# CITY OF ALBUQUERQUE

**Re: Volcano Heights Drainage Compilation Report, Engineer's Stamp  
Dated 12-12-2011 (C10/D000)**

Based upon the information provided in your submittal received 12-12-11, the above referenced report is approved based on the following comments:

Drawing file: FINAL / VH PLATE 1.pdf

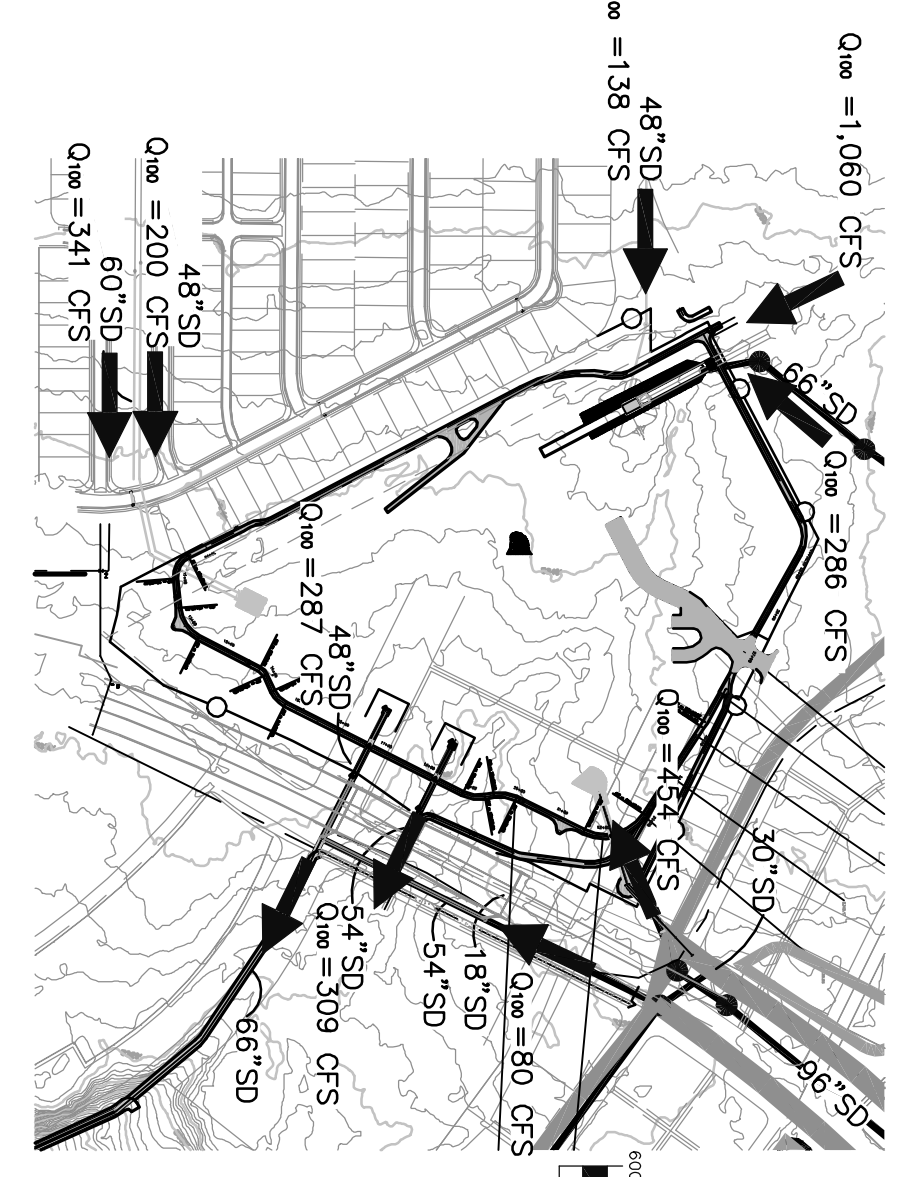
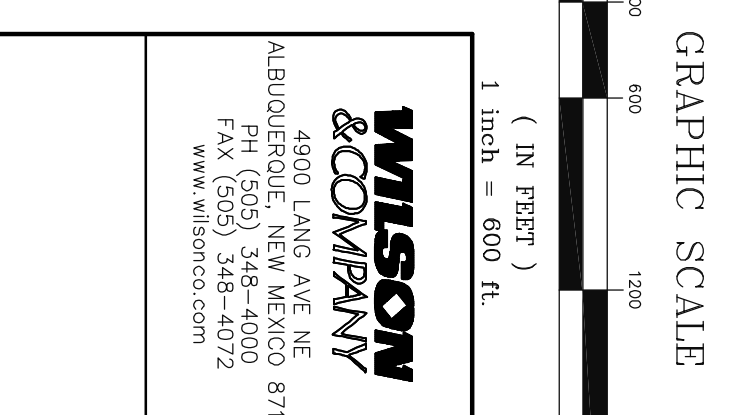
- Proposed discharge from Pond 2 is 470 cfs, and the total discharge from other Basins (4A, 4B, PDN2 ...) is 252 cfs. Therefore, the total discharge from these two locations is 722 cfs which exceeds the 620 cfs at AP1. The discharges from Basins 7, 12B, and A may have to be controlled discharges to meet the 620 cfs.
- Please see enclosed copy of the comments for SAD 228.
